Subject: Partial Objection to Proposed Petrol Station, Shop and Hot Food Takeaway Development

Planning reference...2026/62/90783/E

I am writing to submit a partial objection to the proposed development of a petrol station, shop, and hot food takeaway at 7 Wakefield road, Grange Moor, Wf4 4ds.

Site Plan
1 : 200

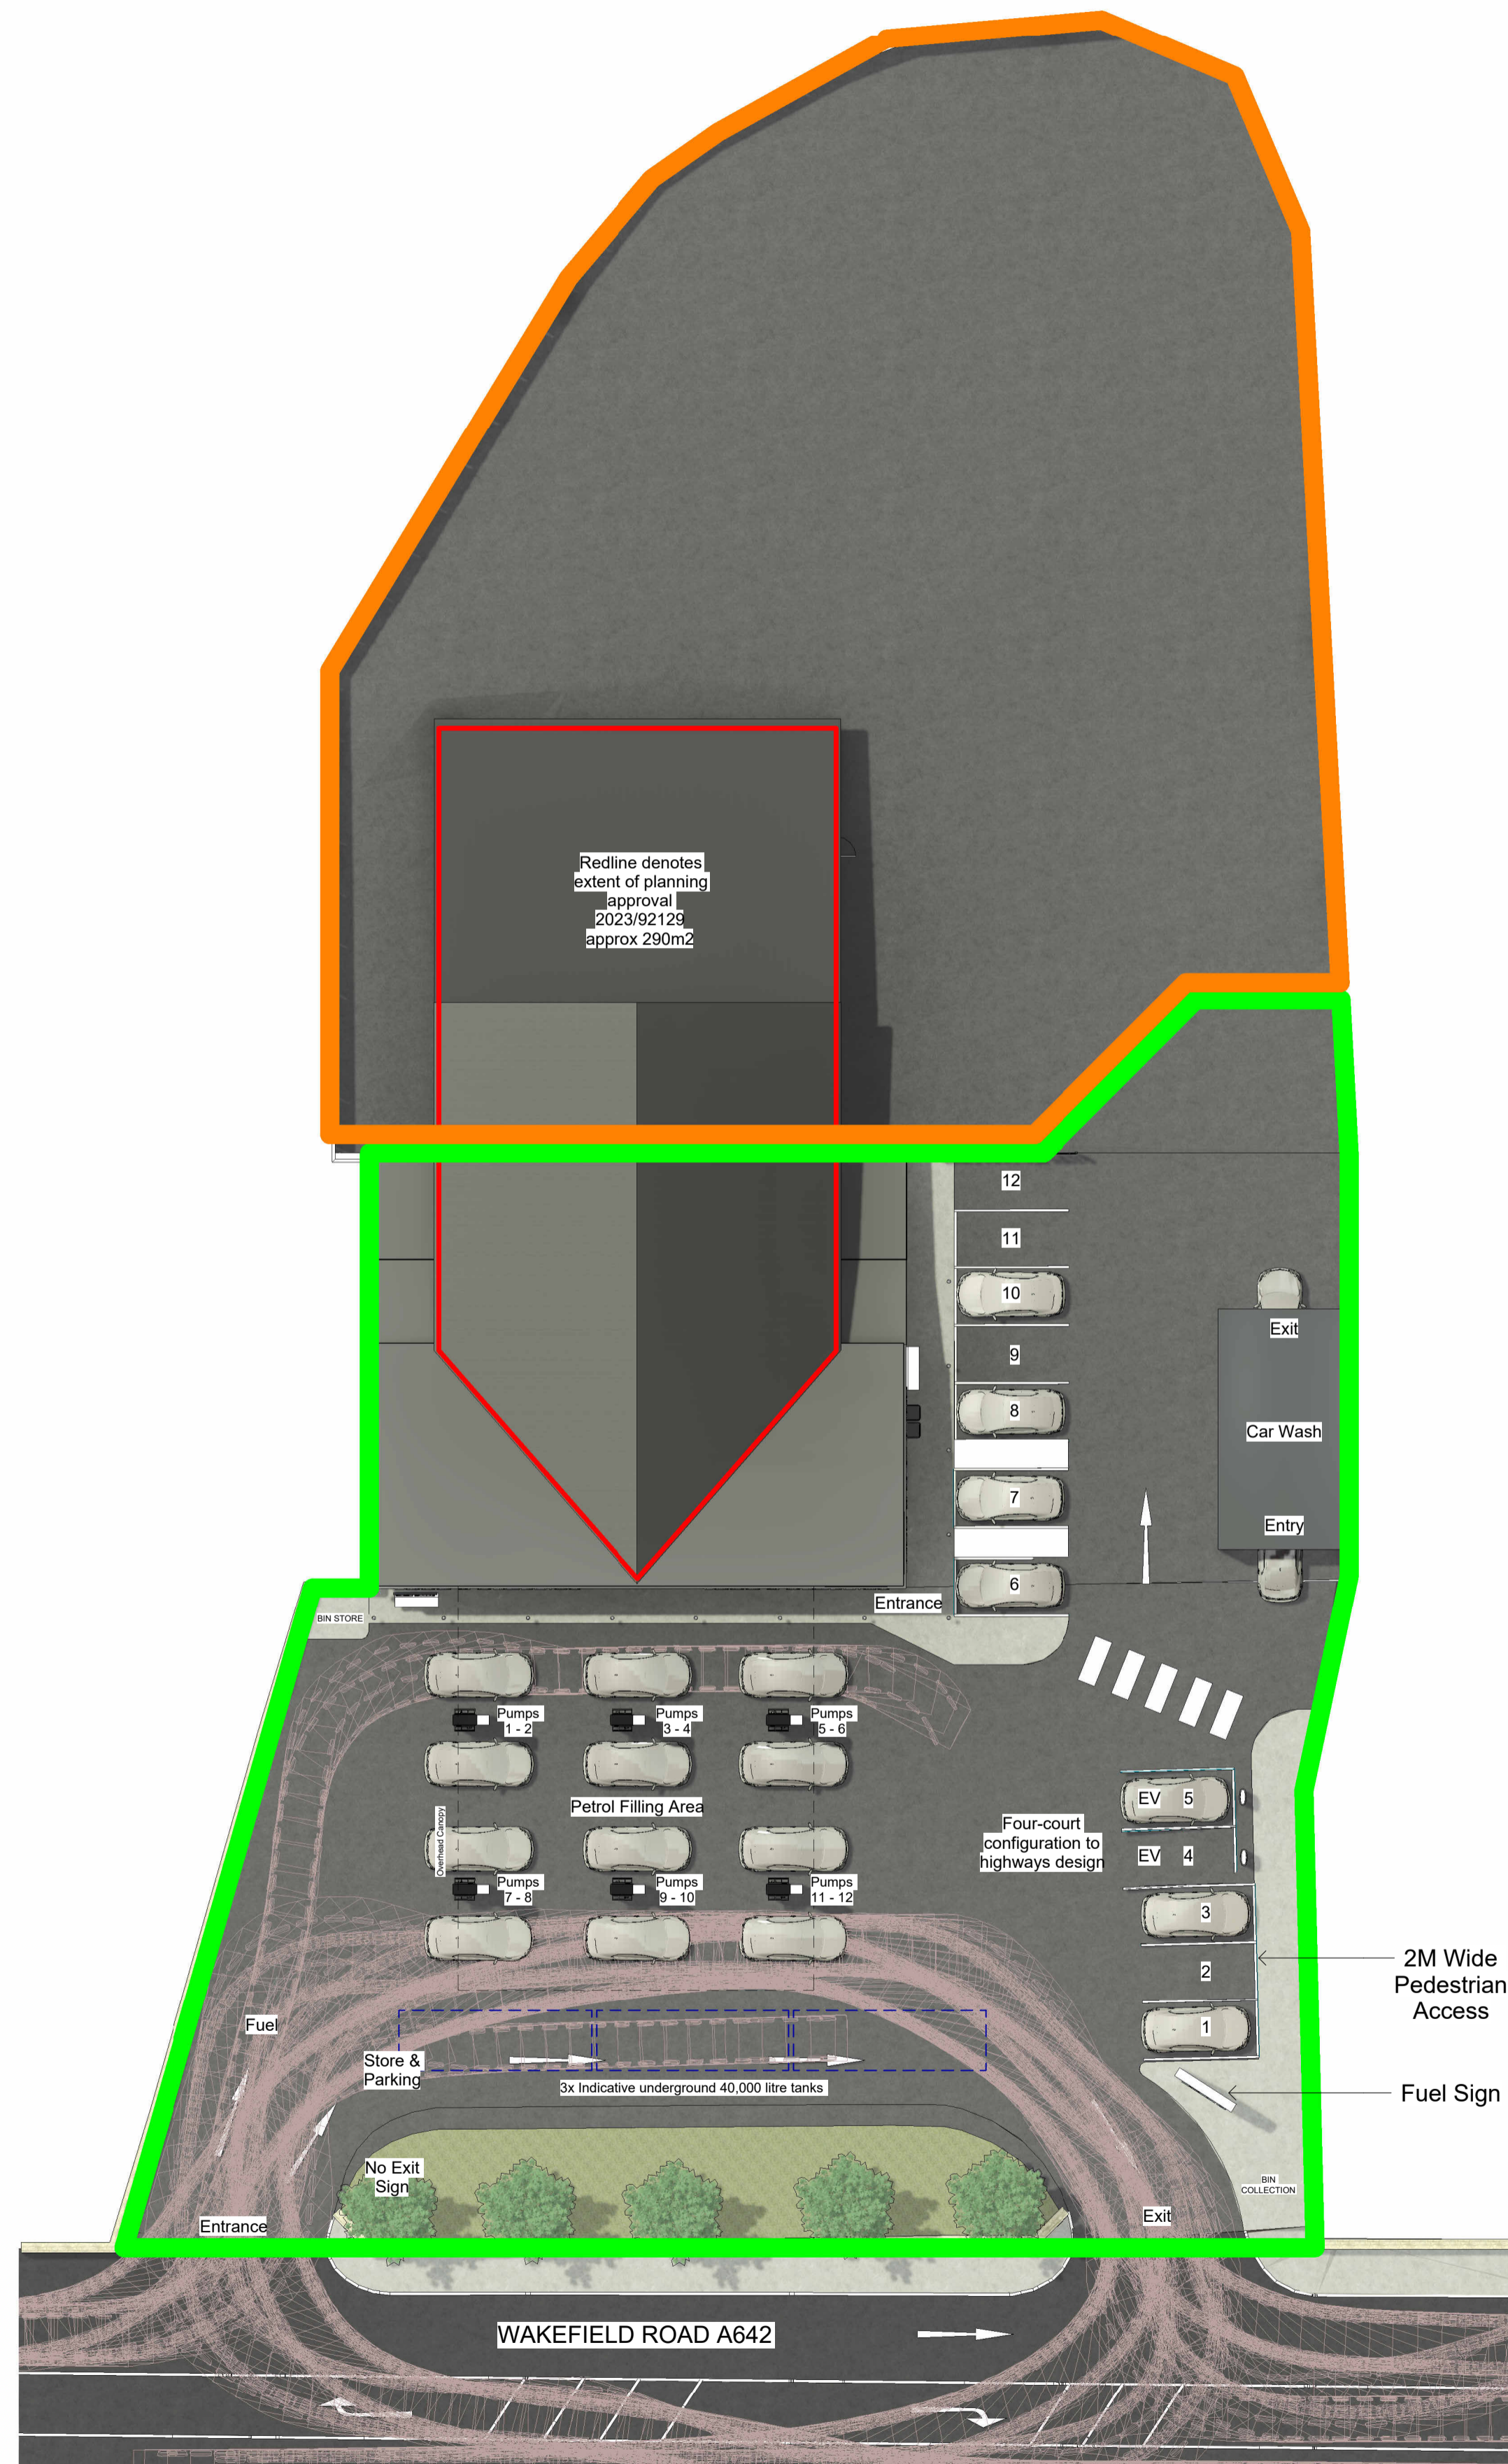
I strongly object to the location of the proposed exit, which is directly opposite our living room window at a distance of approximately 10 metres. This raises serious concerns regarding:

- Noise disturbance from vehicles accelerating and braking
- Headlight glare entering our property, particularly during evening and night-time hours
- General loss of residential amenity and privacy

I would respectfully request that the entrance and exit layout be reconsidered, and ideally reversed, so that the exit is positioned further away from residential properties.
